OUT16/28201

**Mount Owen Continued Operations Project (SSD 5850)
Additional Comment on the Response to the Planning Assessment Commission
Review Report**

Comment by DPI Water

**FIGURE 2.12**  
**Proposed Mount Owen**  
**Conceptual Mine Plan**  
**Final Landform**

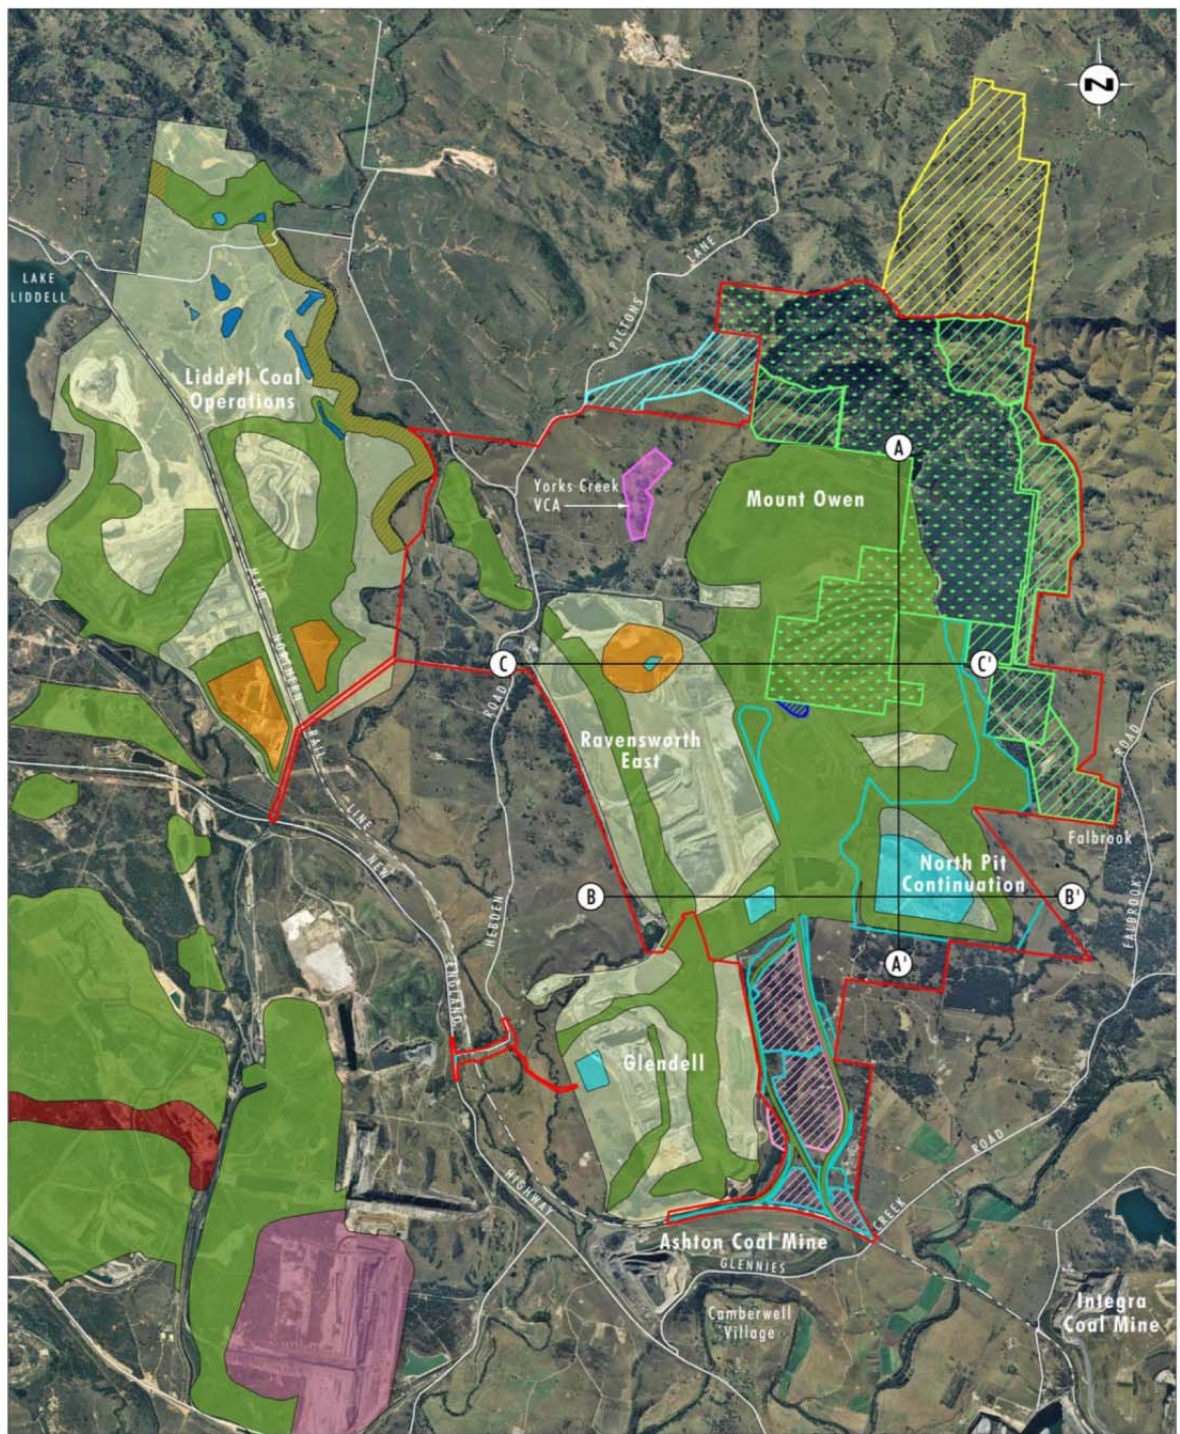
DPI Water understands that for calculating the licensable take in Table 1 and Table 2 that the harvestable right contour was used to convert from hectares to mega litres. DPI Water advises that all water must be appropriately accounted for via a Water Access Licence unless subject to harvestable rights. The context surrounding the verbal advice received is unclear and an incremental approach to final landform water licensing is not consistent with the *Water Management Act 2000*.

As such it is recommended that the proponent liaise with DPI Water to discuss licensing of the final landform and also provide detail and spatial data to demonstrate the conclusions depicted in Table 1 which indicates that additional entitlement is also required from the Jerrys Water Source. It is recommended that this consultation occur prior to project determination to ensure that the impacts of the proposed final landform on the catchments are appropriately understood.

It is noted that in the revised final landform that the Dams on the Forestry Corporation Land will be used for flood detention and not permanently hold water and therefore does not require a WAL.
